Re: Mesa del Sol Tract A - Mixed-use Multifamily DFT Comment Response

The letter outlines the project team's responses to the comments from the May 3, 2023 meeting of the Development Facilitation Team on PR-2023-008551 SI-2023-00778 Site Plan DFT for a mixed-use multifamily development on Mesa del Sol Tract A. The DFT comments are in bold, and the responses are in italics.

**SDP-5.1**

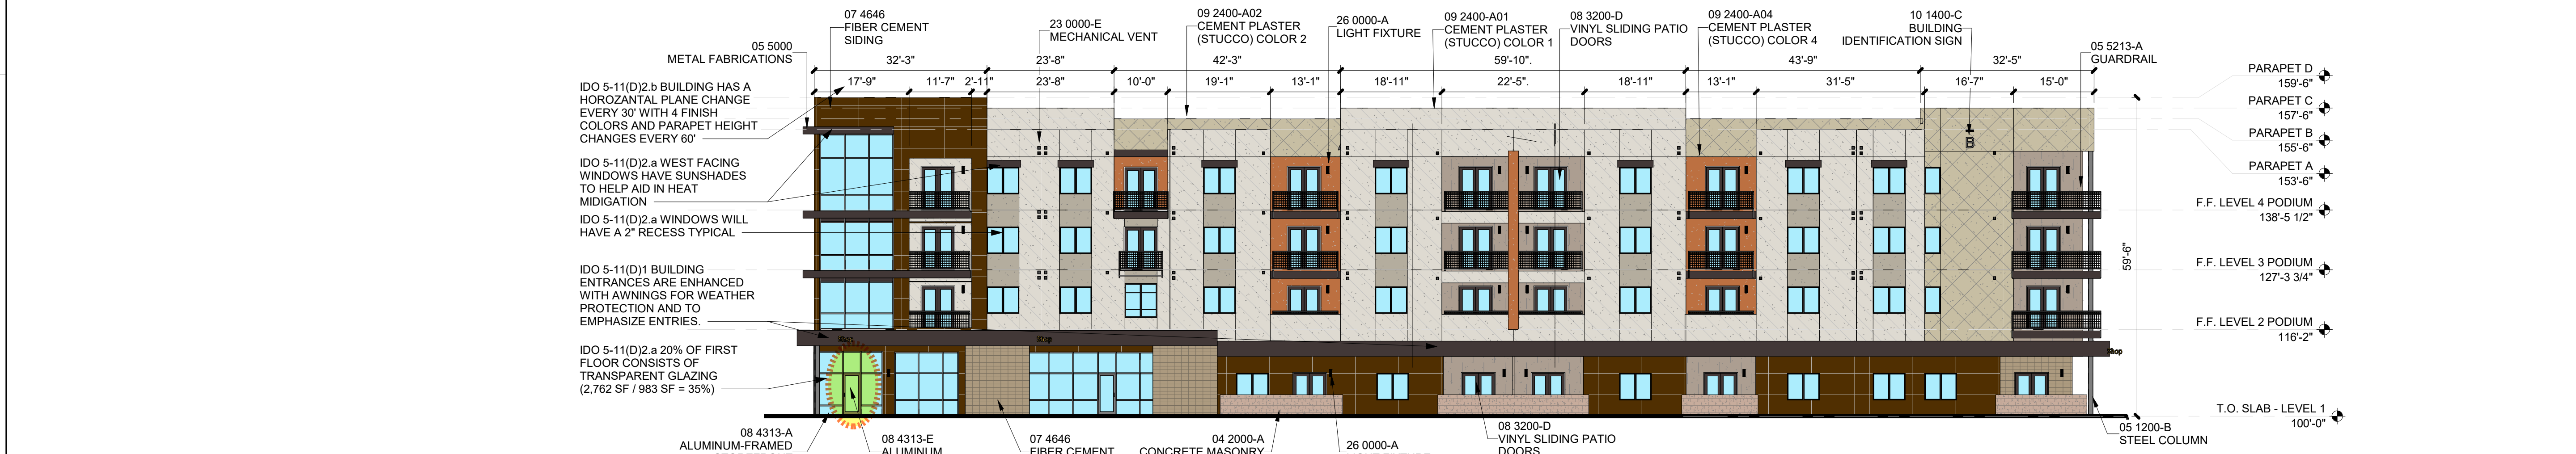
(1) Building Entrances: Show how building entrances are emphasized and provide weather protection. (A, B, D, E, F)

(2) Facades: (a) Windows--

(1) Street-facing ground floor must have 20% in transparent windows.

(2) Windows recessed 2 inches or more must have a 2 inch casing.

(3) West facing windows must use heat mitigation.

(b) Articulation:

(1) One element that is recessed or projected every 30 feet.

(2) Street facing has more than one building finish or color.

(3) Balcony massing, material, or color shall create visual interest.

(3) Roof Design: Any rooflines greater than 60 horizontal feet must have a vertical elevation change of 2 feet.

Building entrances are emphasized by providing windows above the doors. Main building entrances face to the exterior of the side and onto courtyards and are emphasized by recesses and changes in material. The first floor of building A, B, D, E, and F are setback so that the upper floors form an overhang to provide weather protection and a human scale.

Transparent glazing of street-facing facades on the ground floor is detailed on Sheets SDP-5.1-5.5. Buildings A and B have first floor glazing of 45% on the street-facing facades. Building D has first floor glazing of 28% on the street-facing facades. Buildings E and F have first floor glazing of 40% on the street-facing facades. Recessed windows shall be recessed not less than 2 inches and will be surrounded by a casing not less than 2 inches wide as required by IDO Section 5-11(d)(2)(a)2. Windows that face west will use heat mitigation measures including sunshades.

Articulation of the proposed buildings is detailed on Sheets SDP-5.1-5.5. The proposed building elevations include articulation in the form of recesses and projections every 30 feet, variations in color and materials, balconies, and windows. Rooflines include parapets to create visual interest. These parapets meet the requirements of (b)(3) by providing a vertical elevation change of 2 feet for those rooflines that are greater than 60 horizontal feet.

DRAWING NAME  
 CONCEPTUAL  
 GRADING EXHIBIT

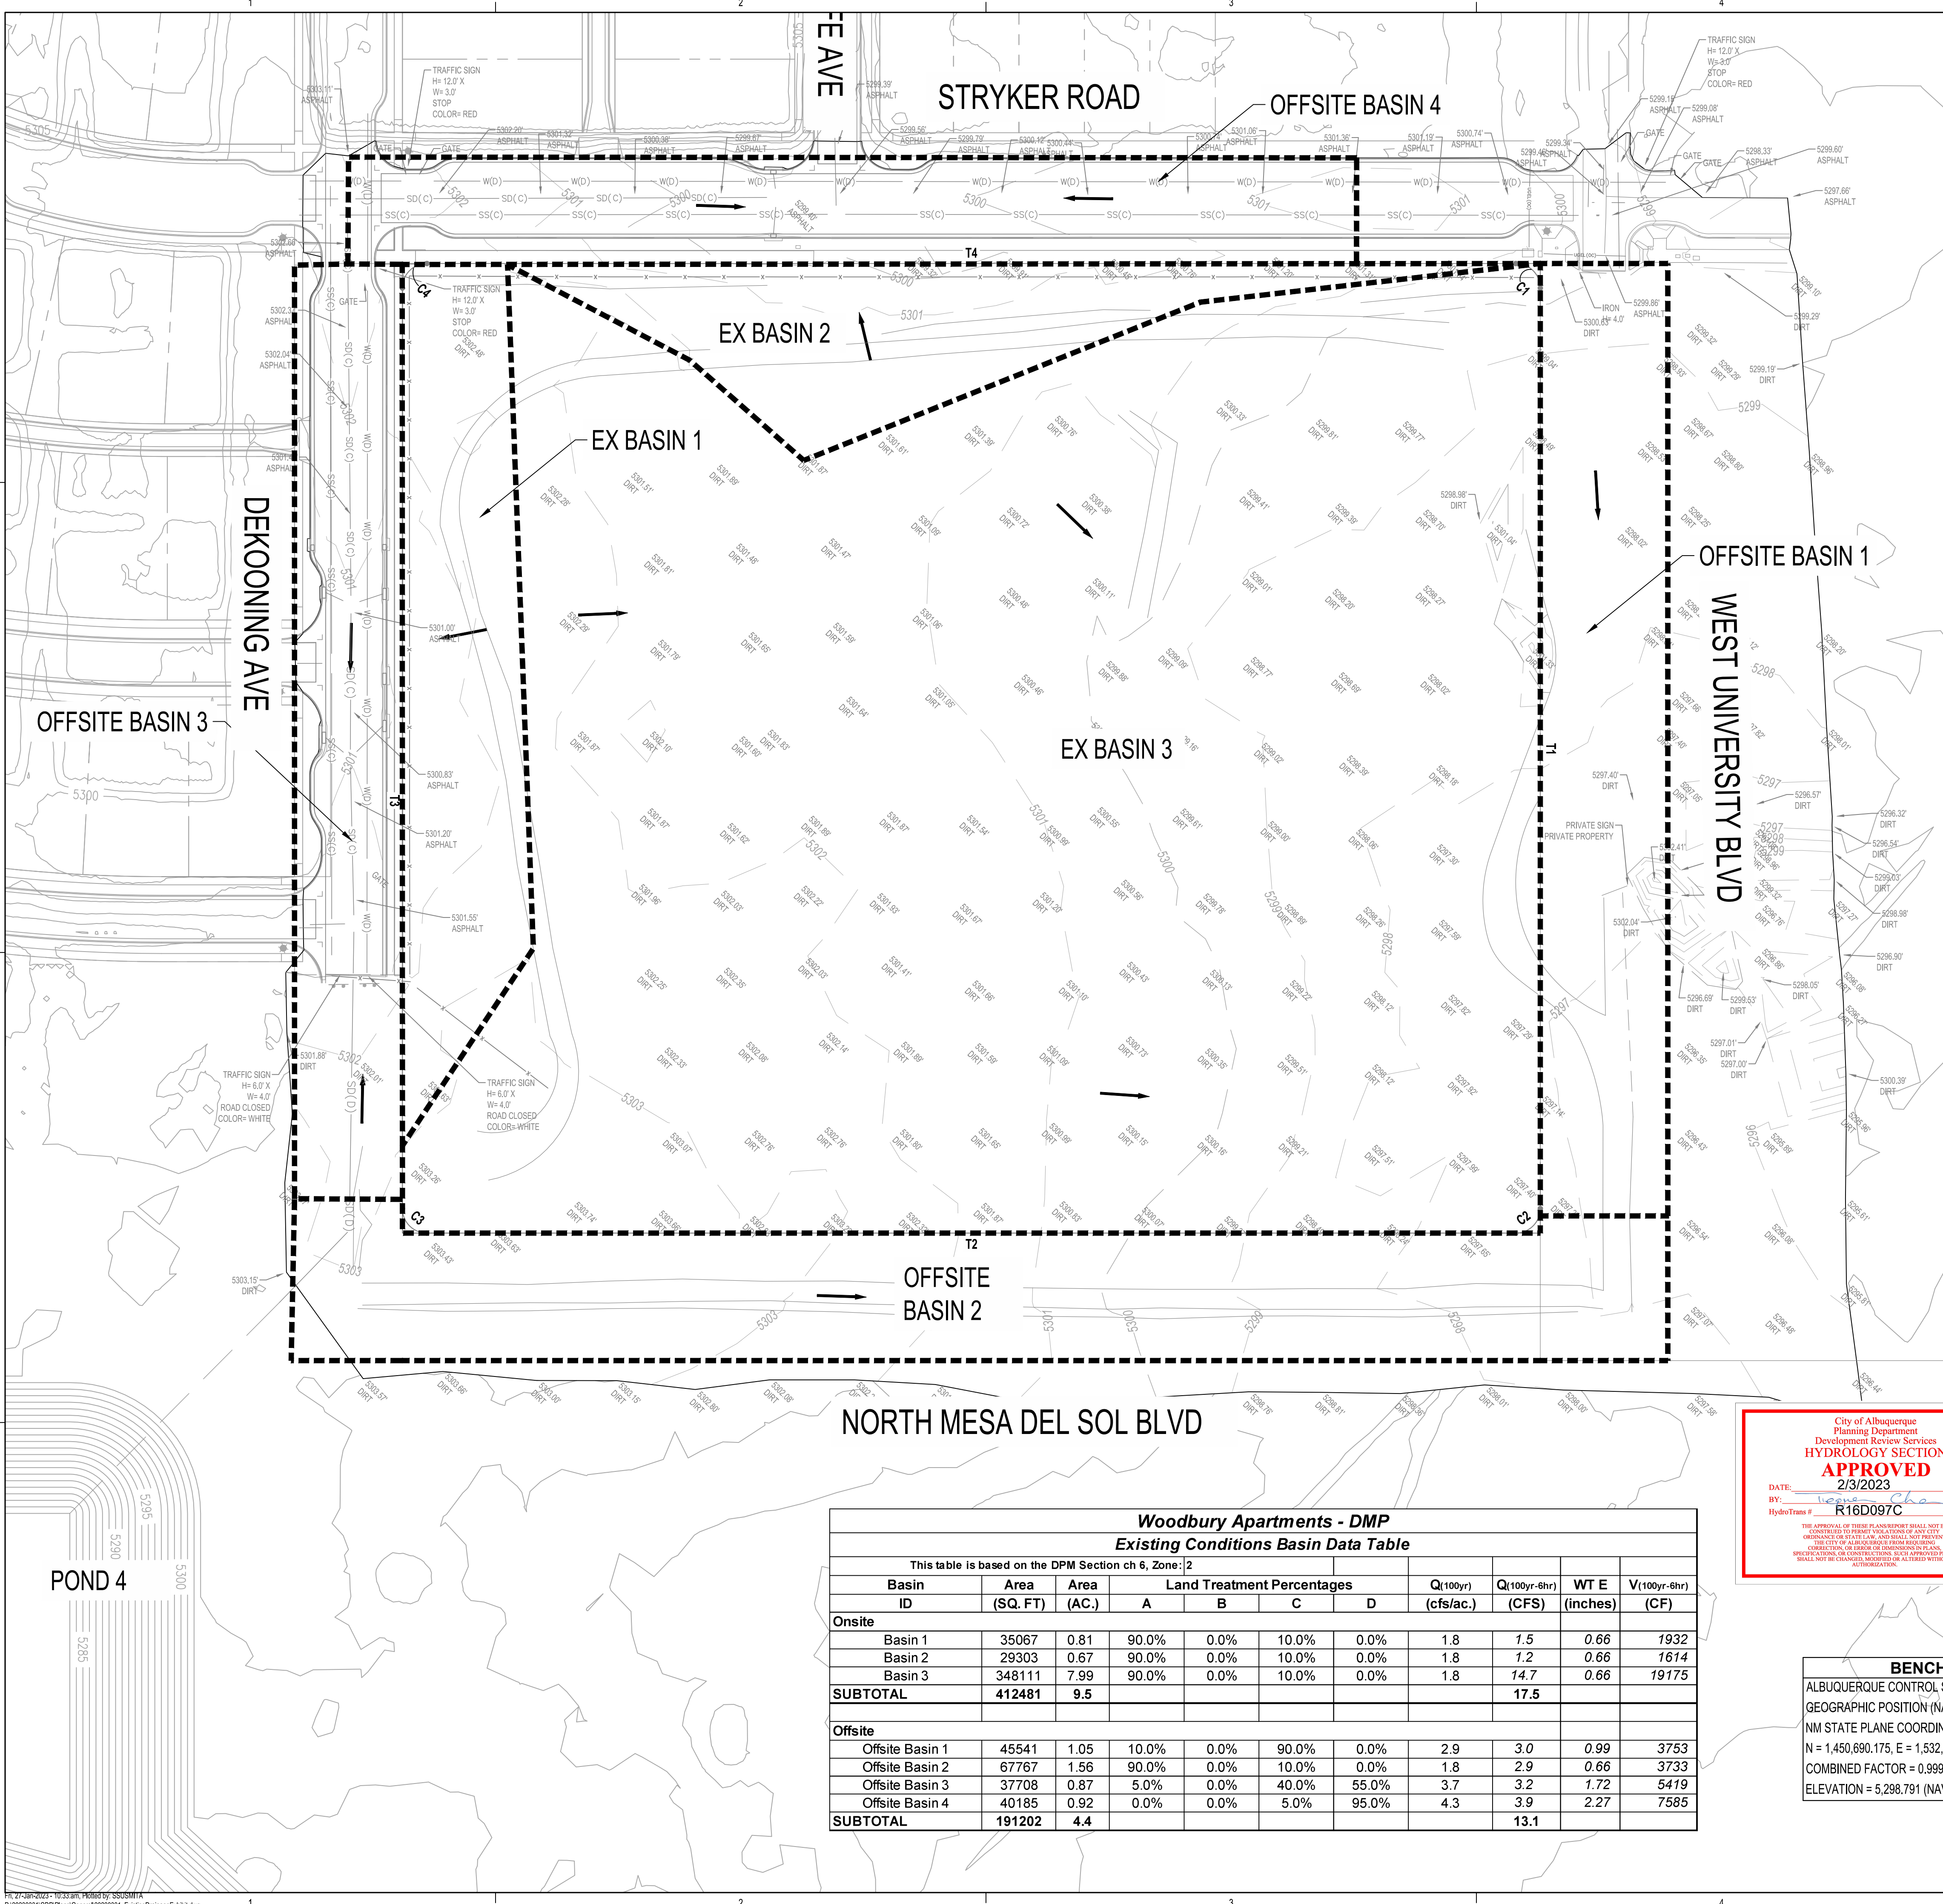
Provide information to indicate how your drainage plan meets MdS requirements for stormwater management (see MdS Level B, pages 8-9). How will the drainage ponds be stabilized: Pond 4 and the pond in the southeast corner? Minimum requirements are Standard Specification 1013. The landscaping plan needs to show stabilization for drainage pond or add a note to Infrastructure list to state: "Pond stabilization per Standard Specification 1013."

Refer to the approved grading and drainage submittal for how we meet the MdS requirements for retaining the storm water quality onsite. Note about stabilizing ponds has been added to the infrastructure list.
